Subject: ADR-17-011, Hazelton Administrative Relief

The purpose of this letter is to provide you with the review agency responses to the above named development application that has been received to-date by Planning and Community Development.

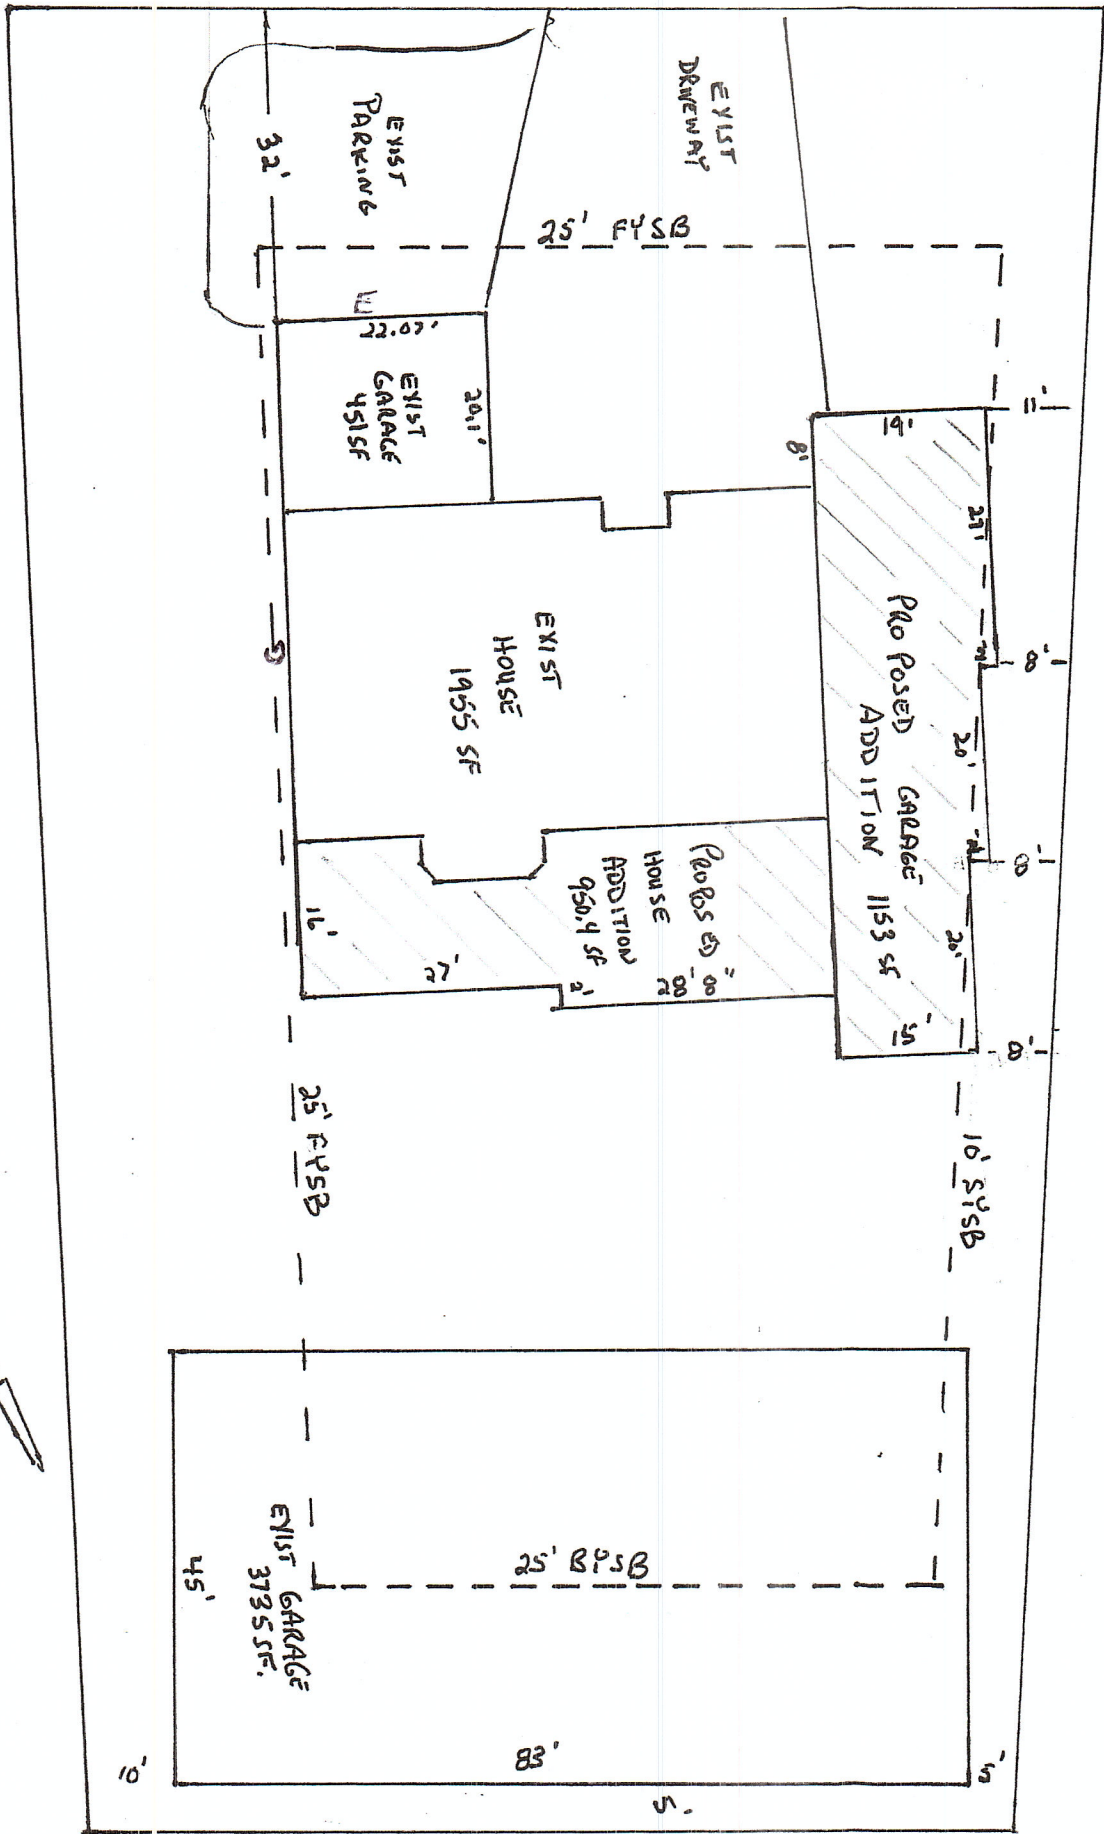
1. The proposed additions has the potential to conflict with the existing overhead electric service line. Please contact the electric field engineer assigned to this area for further coordination (Mr. JC Butterfield, 719-668-5618, Jbutterfield@csu.org) prior to any construction.
